Final and Submitted on 13.05.2020(Amended)

Decision: Grant with conditions

The Welwyn Hatfield Borough Council (WHBC) seeks the views of the Highway Authority for the development of 128 new residential flats. The proposal includes the following:

Drawing / Document Reference						Status
BRW01	MCB	ZZ	B1	DR	A	0308
Project No	Originator	Zone	Level	Type	Discipline	Number
						D5 - P1
						Suitability Revision

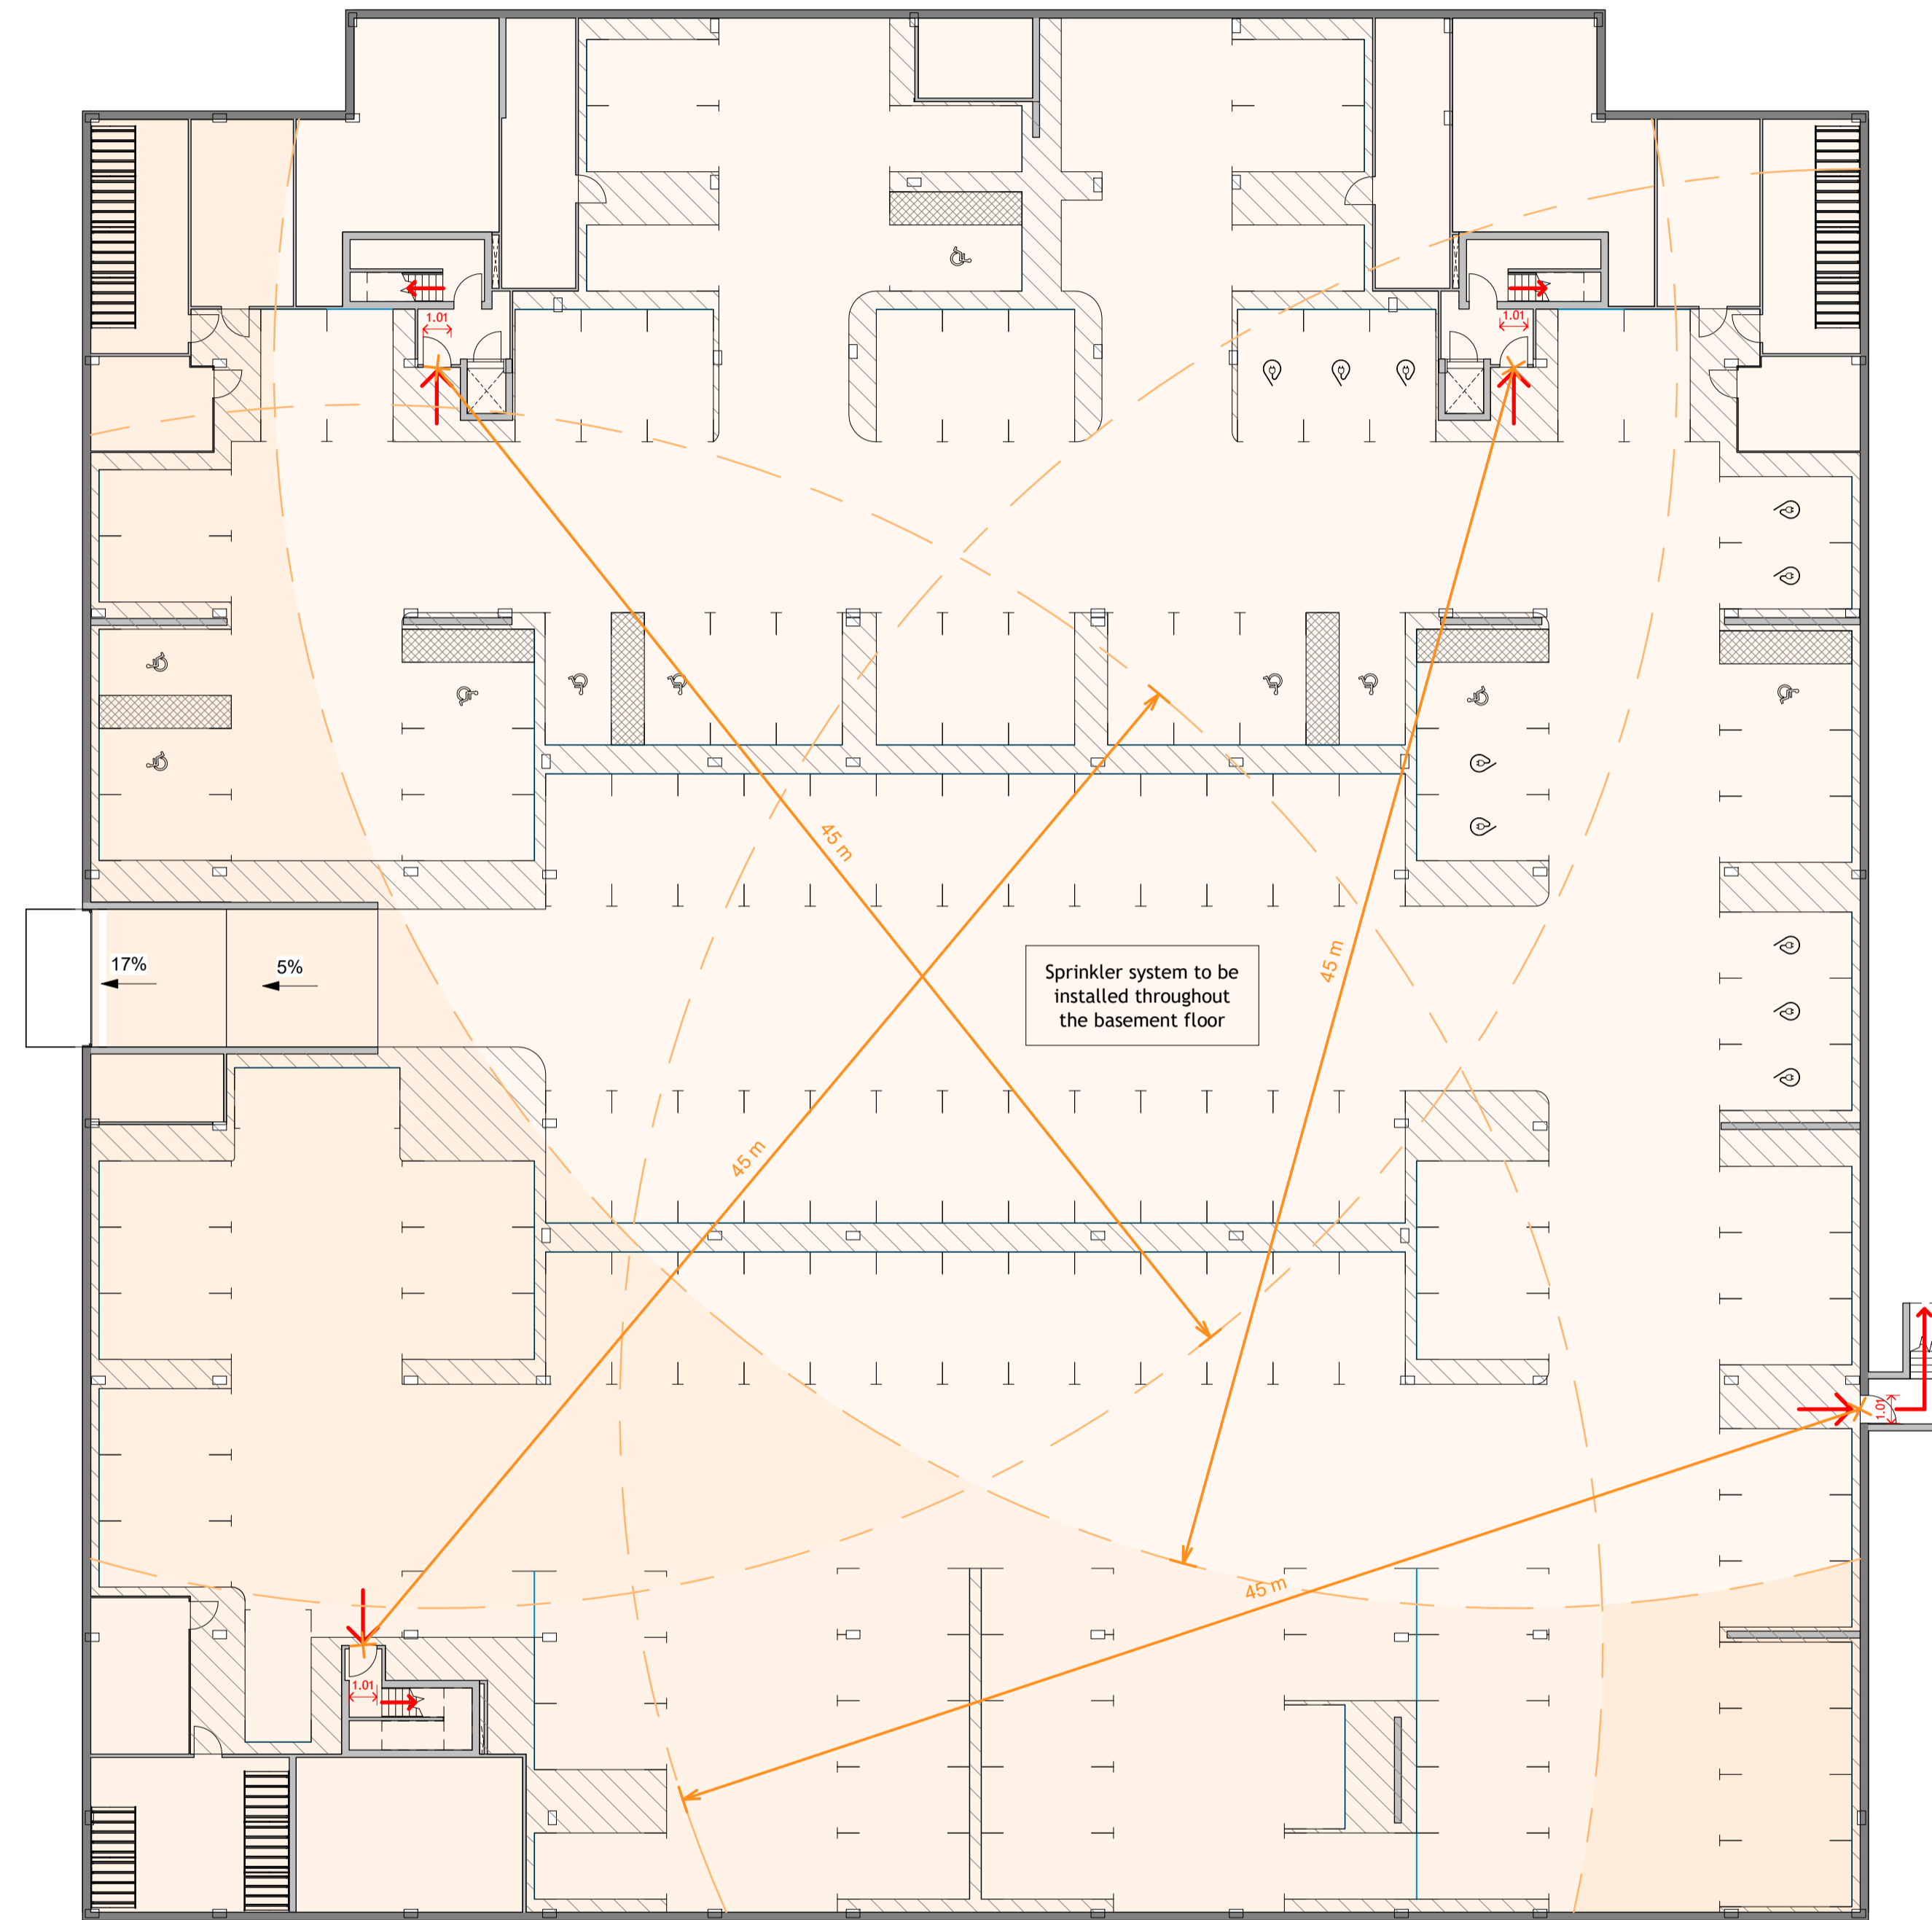
Prior to the first occupation of the development hereby permitted the proposed parking and turning areas as shown on the drawing (Ref- BR01-MCB-XX-B1-DR-A-005, Rev-P1) shall be laid out, demarcated, levelled, surfaced and drained in accordance with the approved plan and retained thereafter available for that specific use.

According to the above standards, the proposed 128 cycles parking spaces on site as shown on the drawing (Ref- - BRW01-MCB-ZZ-ZZ-DR-A-005, Rev- P1) would be acceptable.
